Rezoning Transportation Analysis

Petition Number: 2019-177

Reviewer: Walta Blackmon, PE
walta.brumschine@ci.charlotte.nc.us
704-432-1556

Date	Description
01-15-2020	First Review
02-17-2020	Second Review
04-27-2020	Third Review

REZONING PLAN

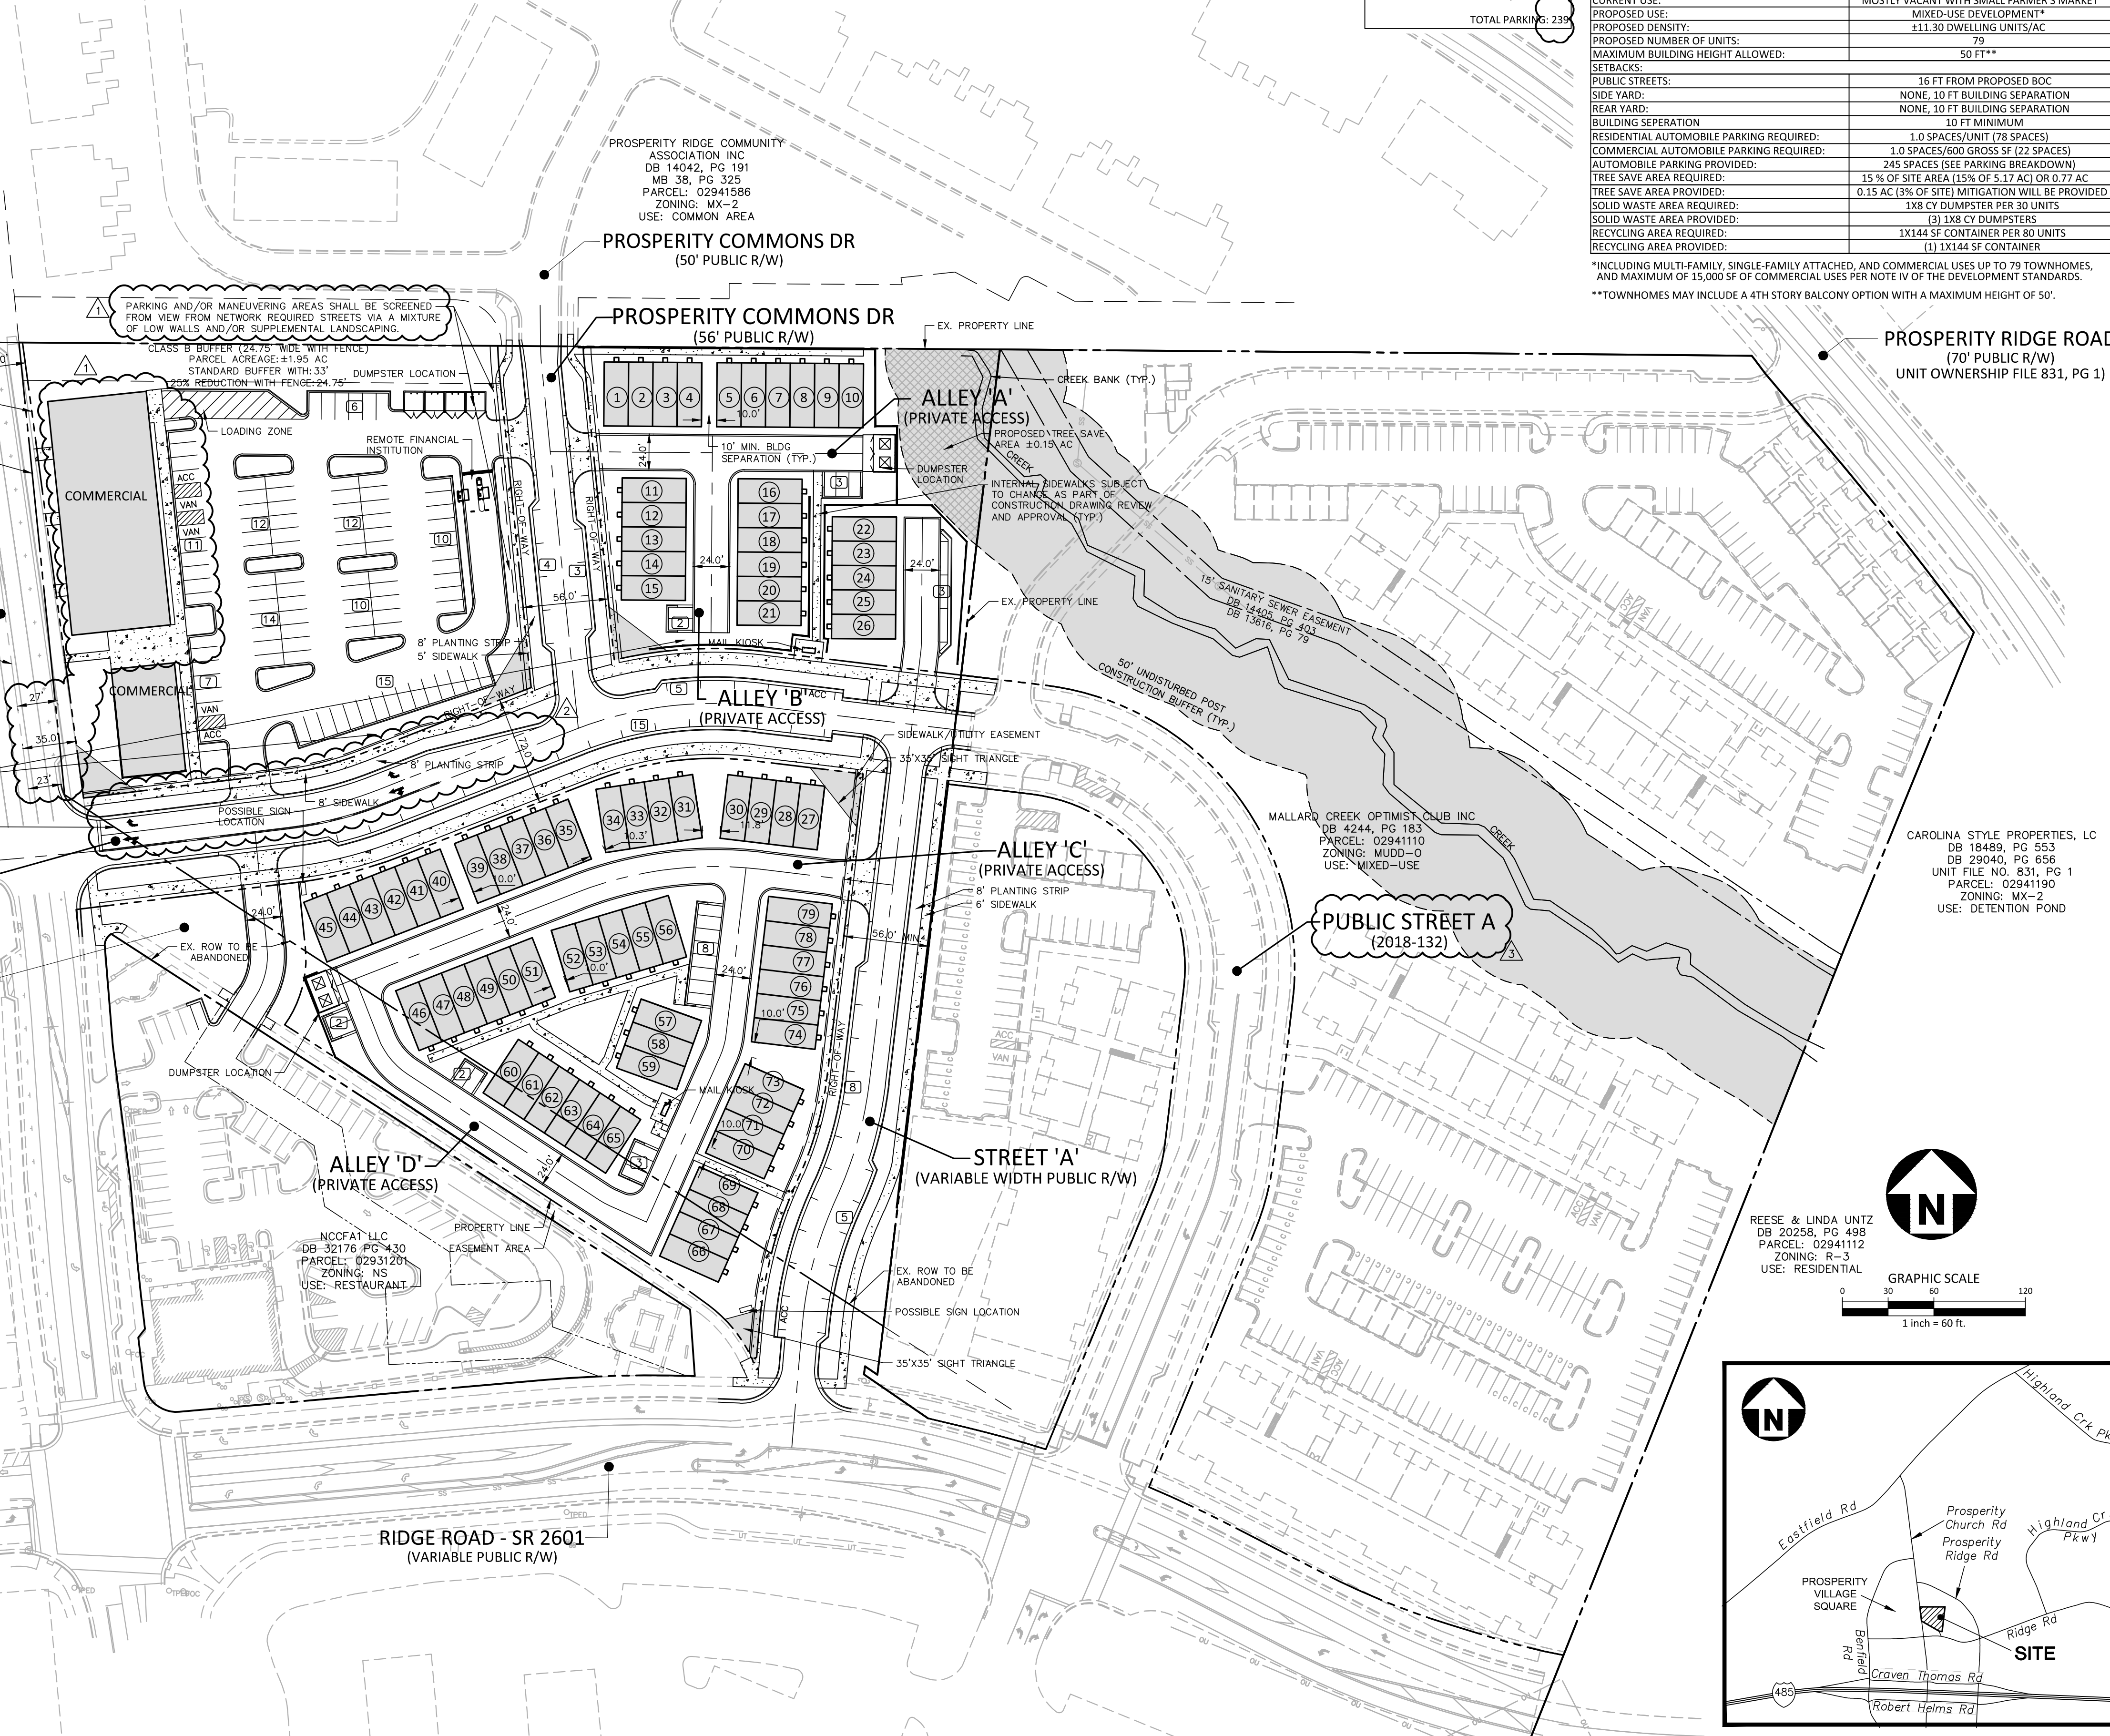
5. New Comment based on revised site plan (4/27/2020) The petitioner should revise the site plan and conditional note(s) by removing the note stating the curb and gutter along Prosperity Church Rd will be constructed by the City project. The petitioner should commit to construct the required ordinance curb and gutter requirement and streetscape along its frontage of 8' planting strip and 6' wide sidewalk.
